West Burton C (Gas Fired Generating Station)

Applicant's Comments on Relevant Representations

Examination Deadline 1

Applicant: EDF Energy (Thermal Generation) Limited
Date: 20 November 2019

Figure 2. HGV Designated Route Plan (Proposed Development Construction)

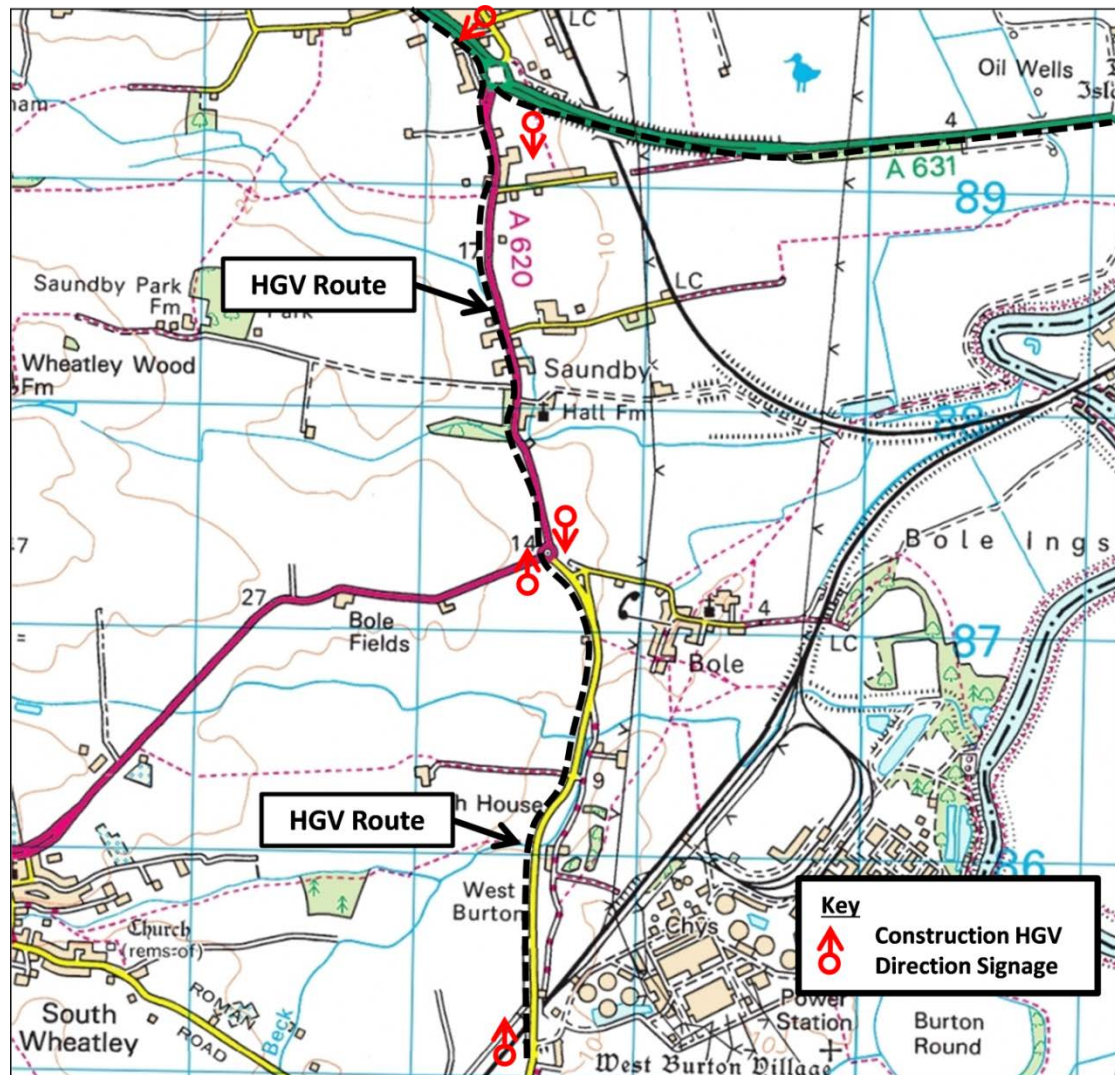
Ref.	Interested Party	Relevant Representation	Applicant's Comments
		<p>expected to peak at 350 two-way movements per day during months 25-27, 112 of these being HGVs during months 18-30. There is no vehicle routing information - the application states that no further quantitative traffic impact analysis is required "as the figures are below the screening thresholds indicated in published guidance". This could however cause problems in Bawtry, depending upon where this significant amount of HGVs go.</p>	<p>the anticipated 3 year construction period) and assignment of up to 26 and 34 construction worker vehicles over the AM and PM peak periods respectively, with up to 4 HGVs inbound/outbound in any one hour forecast. Doncaster Council agreed in July 2017 that no further assessment or modelling of the A631/A638 junction in Bawtry was required within the Transport Assessment (TA) presented as Appendix 6A of Volume II of the Environmental Statement (ES) (APP-051, Document 5.2). Based on the TA, additional traffic generated by construction of the Proposed Development would not be likely to have a significant traffic and transport related effect on the Bawtry Conservation Area.</p> <p>Potential effects of noise and vibration are considered in Chapter 8: Noise and Vibration of Volume I of the ES (APP-037, Document 5.2). This includes an assessment of construction traffic related noise and vibration (paragraphs 8.6.11 – 8.6.16) which uses traffic data from the Appendix 7A: Transport Assessment and calculates the basic noise level (BNL) at 10m from the roadside at relevant roads. The assessment compares the change with and without the Proposed Development, including other committed developments, and predicts a maximum change in BNL of +0.7 dBA (refer to Table 8-29 of Chapter 8: Noise and Vibration) as a result of construction traffic associated with the Proposed Development. This BNL change is classified as a 'very low' magnitude impact (refer to Table 8-10 of Chapter 8: Noise and Vibration) and results in a negligible (not significant) effect on the affected roads (a Significant Observed Adverse Effect Level (SOAEL) is set at a +3 dB and the Lowest Observable Adverse Effect Level (LOAEL) is</p>

Ref.	Interested Party	Relevant Representation	Applicant's Comments
		<p>In the absence of a traffic routing analysis, we would have concerns with an approval of this development.</p>	<p>set at +1 dB). Given that traffic flows associated with the Proposed Development at the A631/A638 Bawtry Junction would be lower than those flows at the affected roads within the scope of the TA, it follows that the BNL change at the A631/A638 Bawtry Junction and within the wider Bawtry Conservation Area would also be classified as not significant. An incremental adverse impact on the historic character of the Bawtry Conservation Area as a consequence of the Proposed Development would therefore not be considered likely.</p> <p>A traffic routing analysis and junction capacity assessments for the junctions, agreed to be within the scope of the assessment, are provided within Section 5 and Section 9 respectively of Appendix 7A: Transport Assessment (APP-052, Document 5.2). Construction worker routing is illustrated in Appendix E of Appendix 7A: Transport Assessment (APP-052, Document 5.2). An HGV routing plan is provided as Figure 2 of the Framework Construction Transport Management Plan (CTMP) (APP-140, Document 7.6).</p>
